Our Reference: 79BA – 880 – 2
Your Reference: SSD - 7311

11 April 2016

Subject: Proposed Research & Education Facility (SSD – 7311)
Taronga Institute of Science & Learning
Bradleys Head Road, Mosman

The referenced landscape plan was prepared by NBRS & Partners, Milsons Point (Drawing Ref. No. 14490, Drawing Nos. LDA00 – LDA04, Issue B, Dated 24/11/2015).

14490-LDA02- F

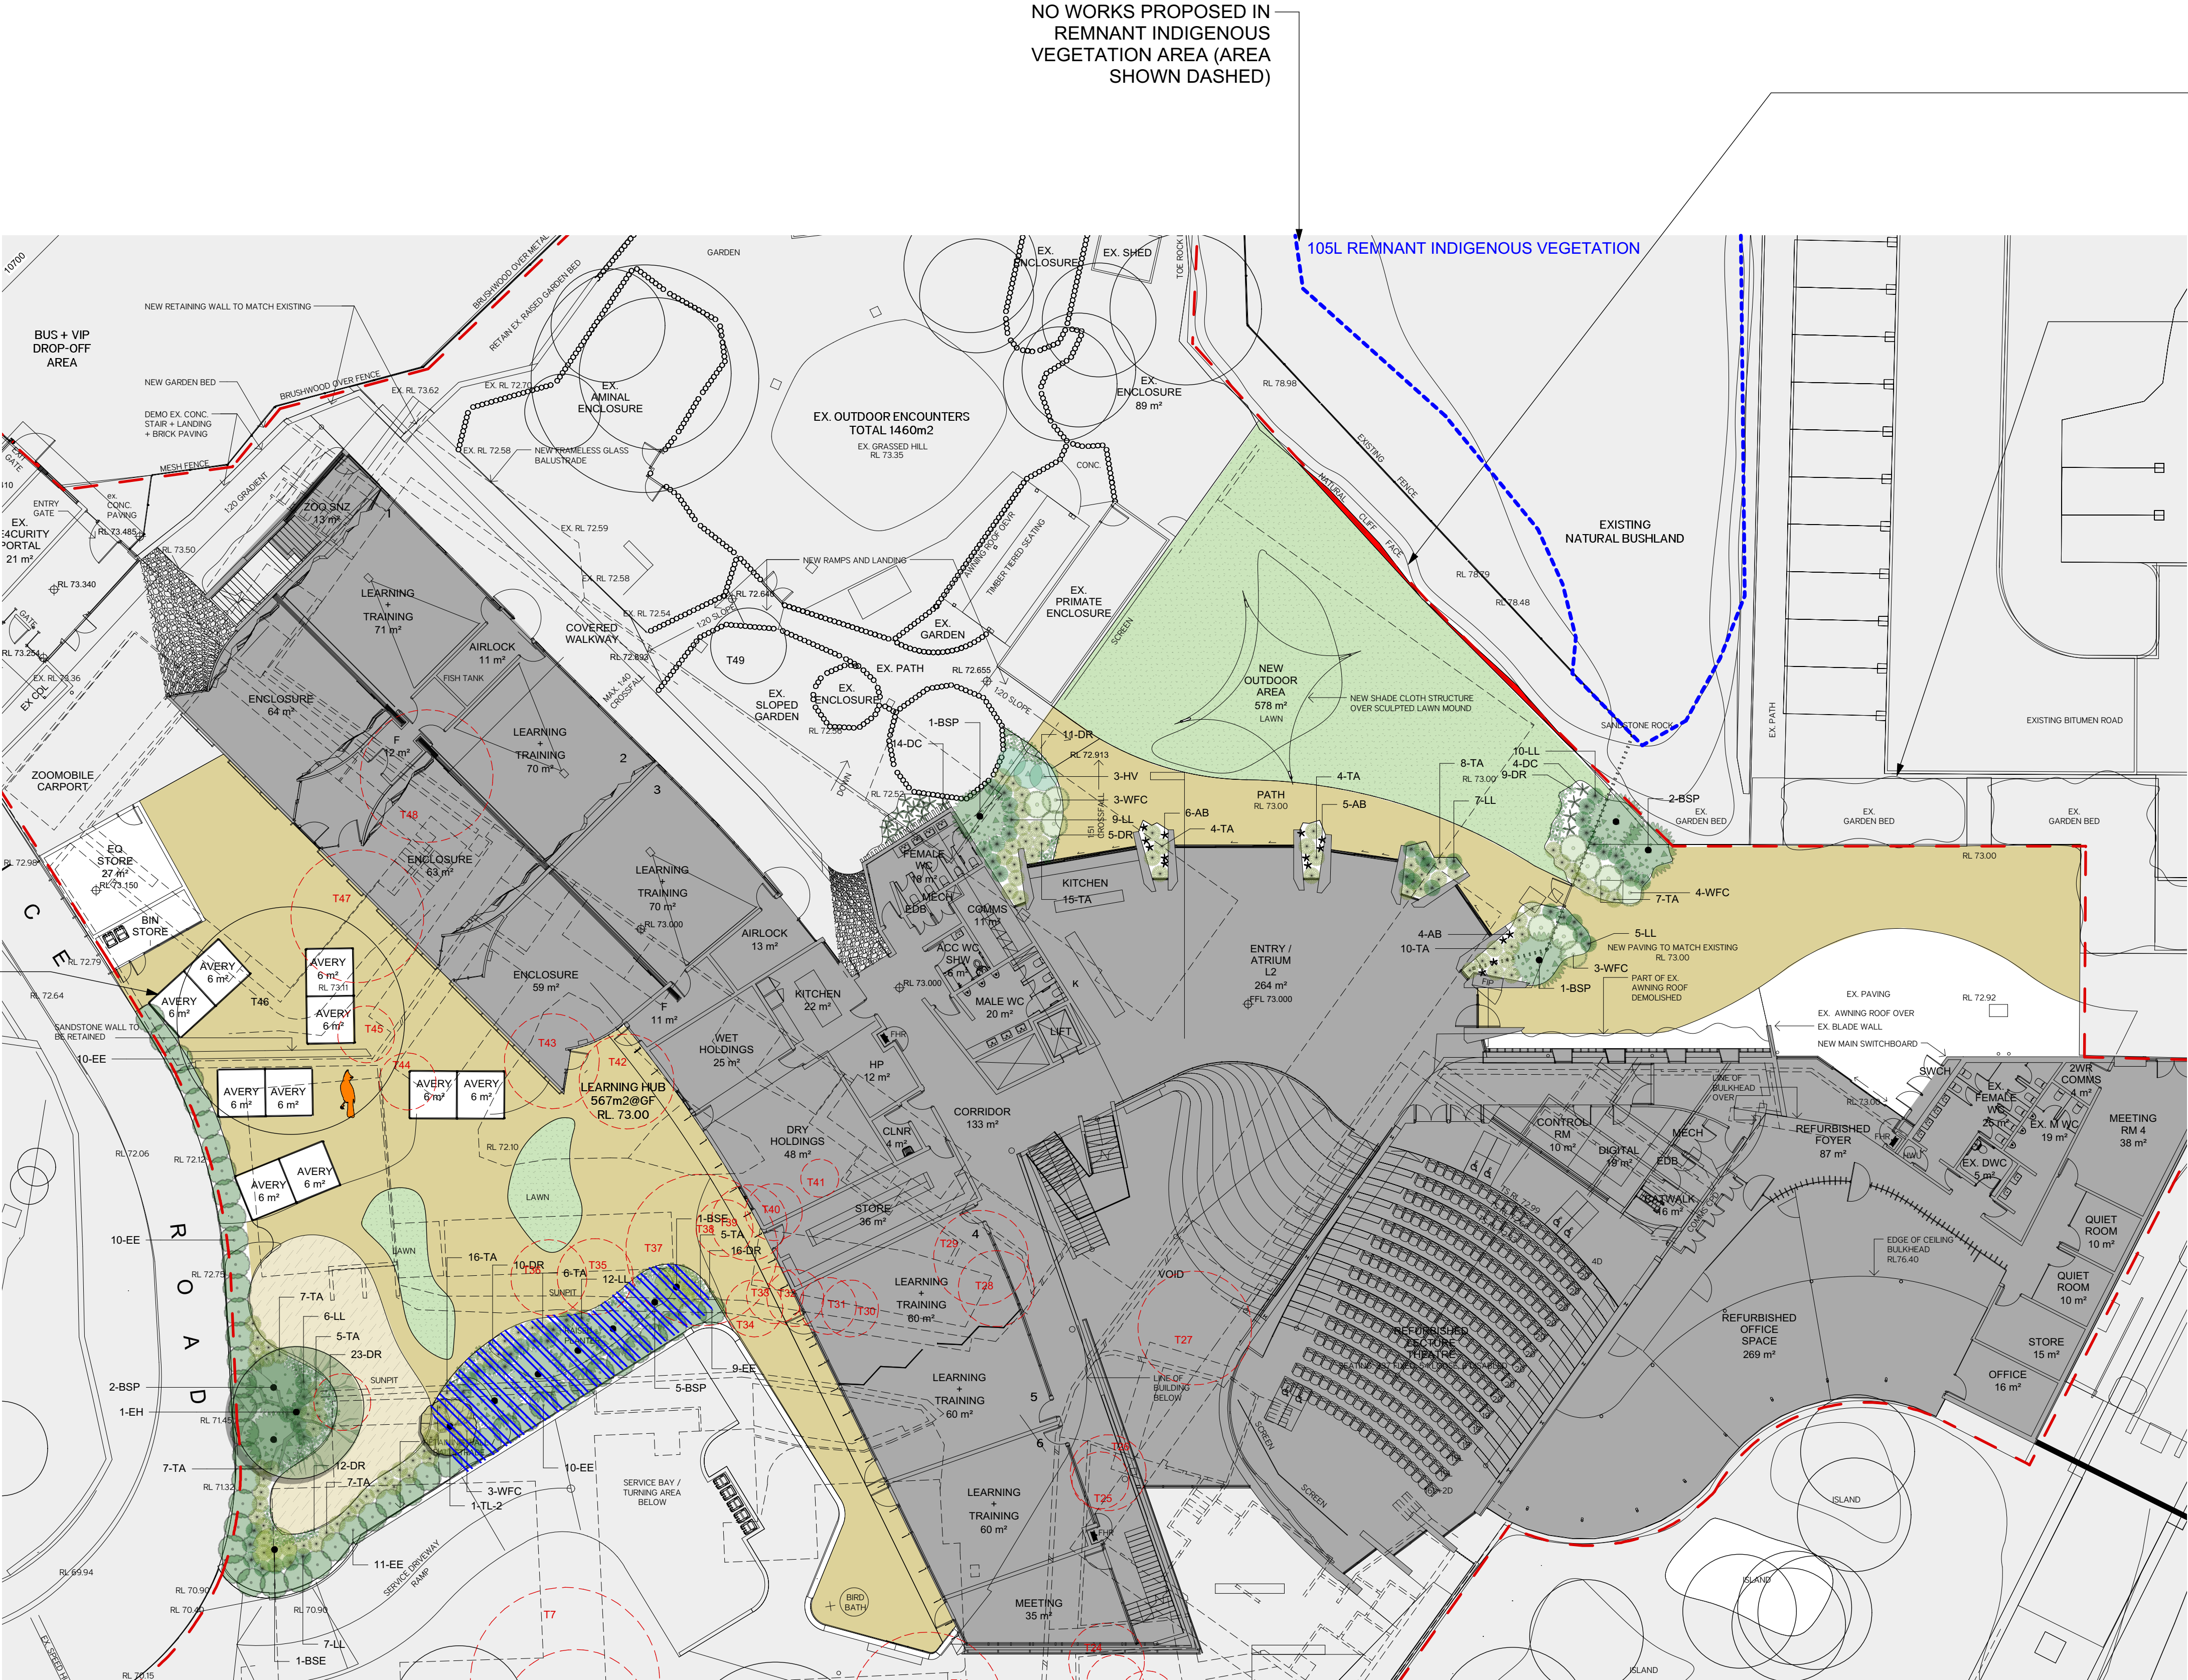
'The Bushfire Assessment – Taronga Conservation Society Australia, prepared by Sydney Bushfire Consultants and dated 9 November 2015 recommends that an Inner Protection Area (IPA) is established as an Asset Protection Zone. The recommendation for the IPA requires that trees and flammable shrubs are separated from buildings. Please clarify the consistency of the landscaping plan with this recommendation. The Department notes that the landscaping plan appears to include groundcover within the IPA.'

In addition, the majority of the grounds directly adjacent to the building envelope, is paved or hardstand area, and free of all vegetation. Canopy trees also generally appear to be well removed from the building fabric. Vegetative groundcovers are also fully acceptable and compliant within an IPA, however they should be maintained at a minimum height (e.g. lawns and grass maintained at <50mm).

Finally, there are some small garden beds proposed adjacent to the building. A review of the plantings list shows some species with good fire resistant properties have been selected, (although no plant could be considered as never being 'flammable'), and it is a considered opinion that these plantings are acceptable, given the low levels of bushfire risk overall, and that the amenity of the site is also considered to be an important aspect of the development.

Overall, the proposed canopy coverage within the study area appears to be well within the requirements for an 'Inner Protection Area' (IPA) – as per *Planning for Bushfire Protection 2006*.
